The Secretary  
NSW Department of Planning, Industry and Environment

17 July 2021

I refer to the Department's below email of 29 June 2021 regarding the notice of exhibition of the Environmental Impact Statement (EIS) for State Significant Development SSD-10391 New Liverpool Primary School for 'Construction of a new school building of up to four storeys including core school facilities, teaching spaces and support units and associated works including tree removal, signage and landscaping' at 18 Forbes Street, Liverpool (Lot 1 DP 1137425) in the Liverpool City Council Local Government Area (LGA). Submissions need to be made to the Department by 27 July 2021.

Site Plan from Endeavour Energy's G/Net Master Facility Model

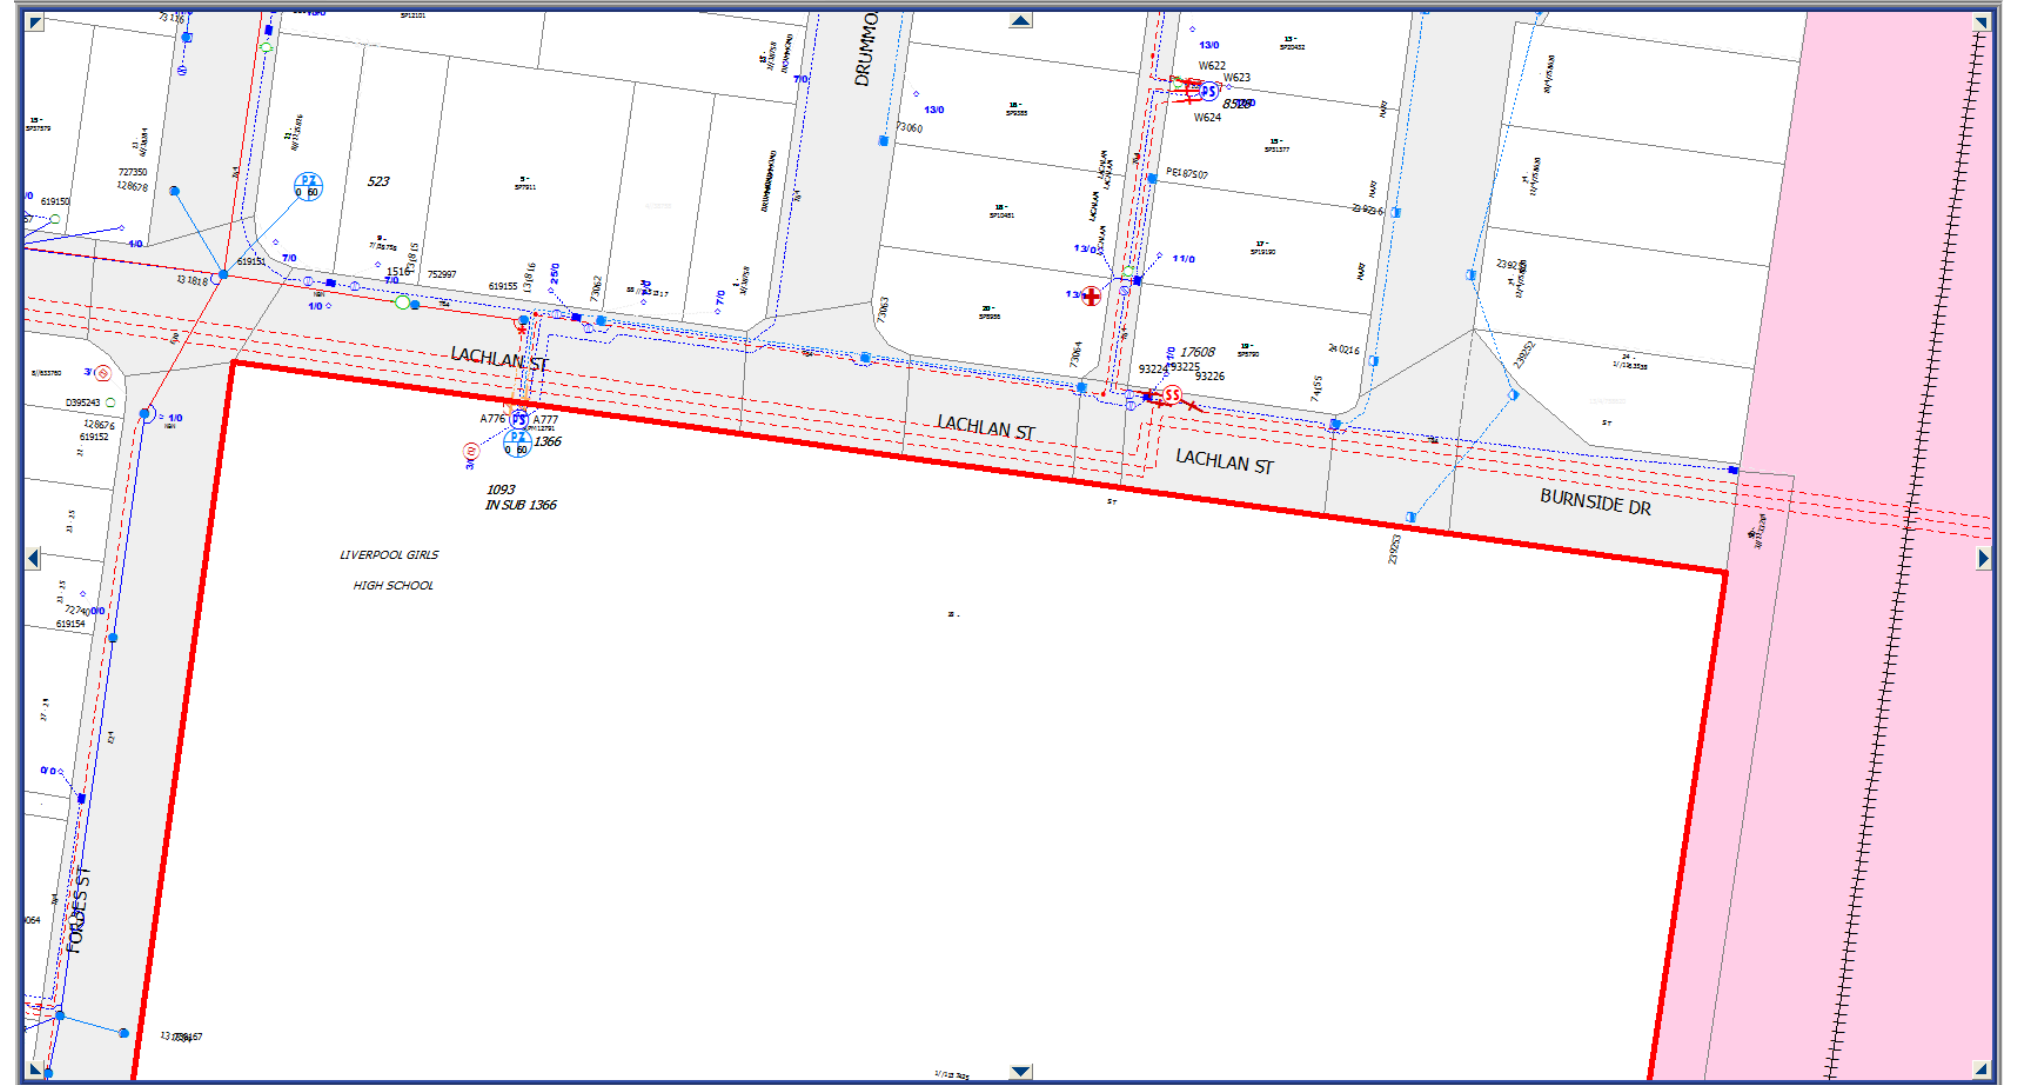
As indicated the below site plans from Endeavour Energy's G/Net master facility model only shows the Endeavour Energy network and does not show electricity infrastructure belonging to other authorities or customers owned electrical equipment beyond the customer connection point / point of supply to the property. However from the extracts of Google Maps Street it is evident there are additional streetlights to intersection of Lachlan Street / Burnside Drive and Hart Street. Following enquiries by Endeavour Energy's Streetlighting with Liverpool City Council it appears the additional streetlighting is owned by NSW Health.

The additional streetlights to intersection of Lachlan Street / Burnside Drive and Hart Street appears to be owned by NSW Health.
